CITY OF PORTLAND BUILDING PERMIT

PERMIT ID: 2012-50421

has permission to **Installing stairs**

Robert Wiener - Re: New Park St images

See curbing
revision
4/1/13

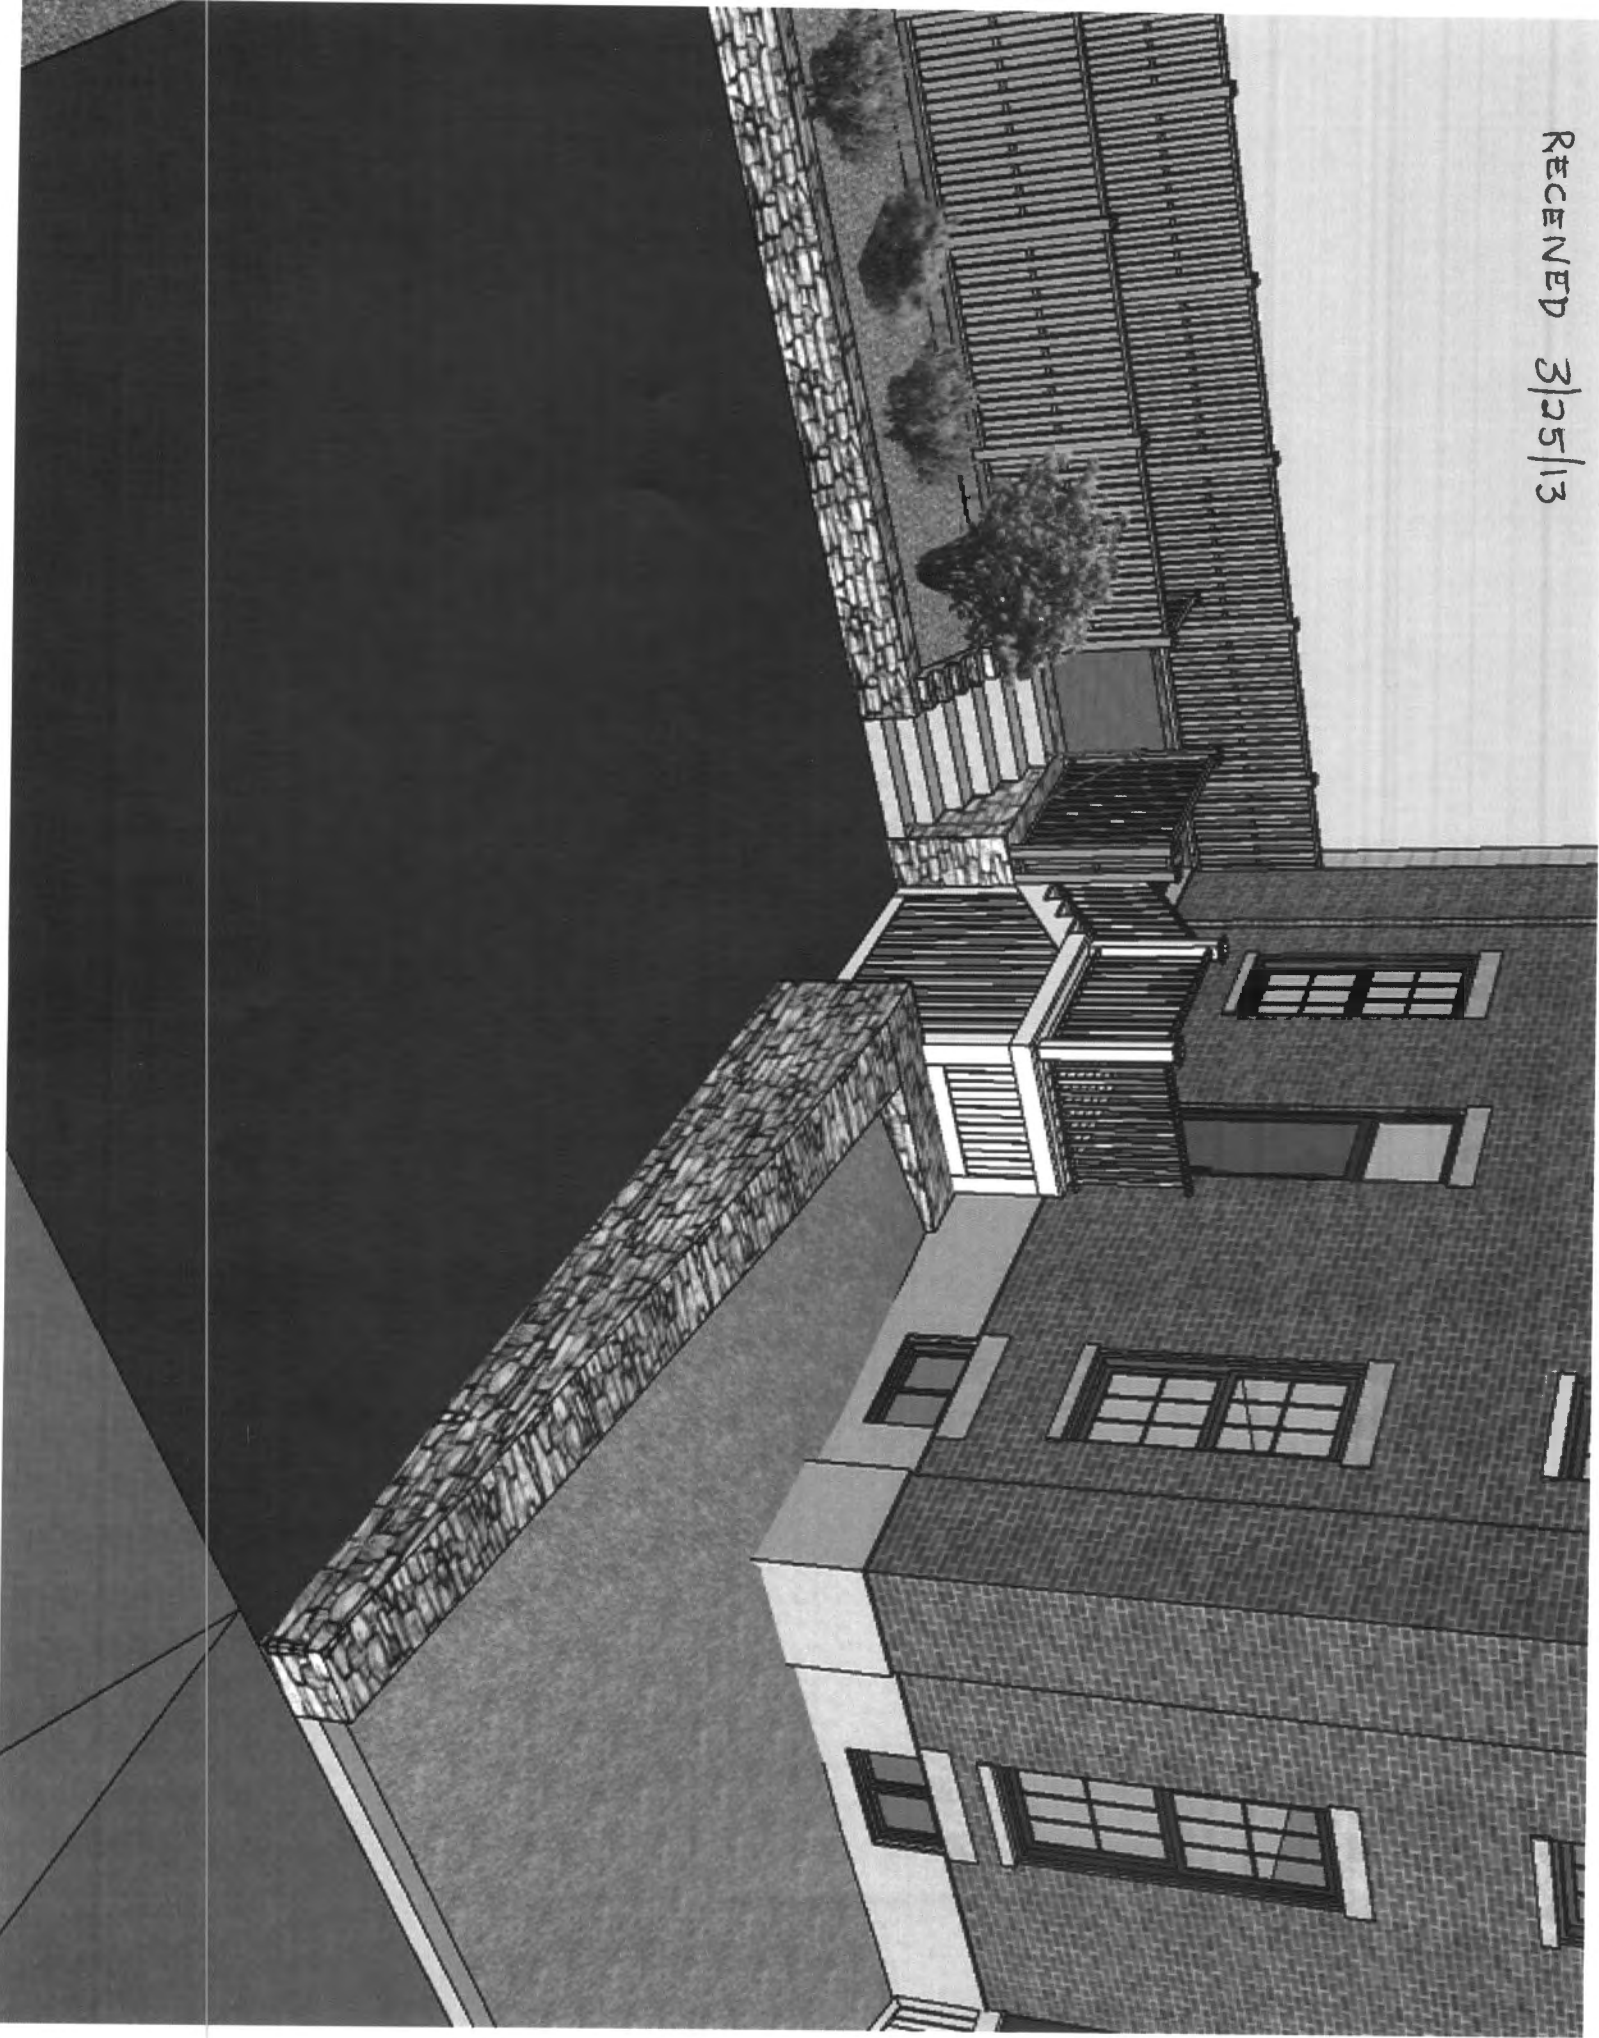
- where curb to the right of the steps slopes down to match the end of the first granite step, can you make the transition a straight slope, and a little longer, more gradual?
- hoping the mason can round the corners of the first step, where it sticks out (we talked about this, I'm guessing it's not worth trying to draw it.)
- show the post bases with a minimum height of 7.25" (1x8)
- We want to make sure we have an image with dimensions, showing component sizes, heights, the amount of that 3.5" projection, etc.

Thanks for speaking with me this morning, and for your help with this matter. I'm attaching some of Andrew Mayer's sketches and the tax photo. It appears that the bottom of the stairs may have projected beyond the curbing at the front of the yard.

I think you are good to go. The city engineer has given the go-ahead for the bottom step - see below. I think we're happy with everything else, except we'd like to see the iron handrail return into the side of the newel, instead of wrapping around the front. I think it's almost as easy to grab there, as it would be from the front, and it would be good not to have it on the front of the post. And at the top it appears that the short level rail hits the pilaster just below the panel molding - that looks good.

Public Services has reviewed this request and we have no issues with the bottom granite step being installed as proposed.
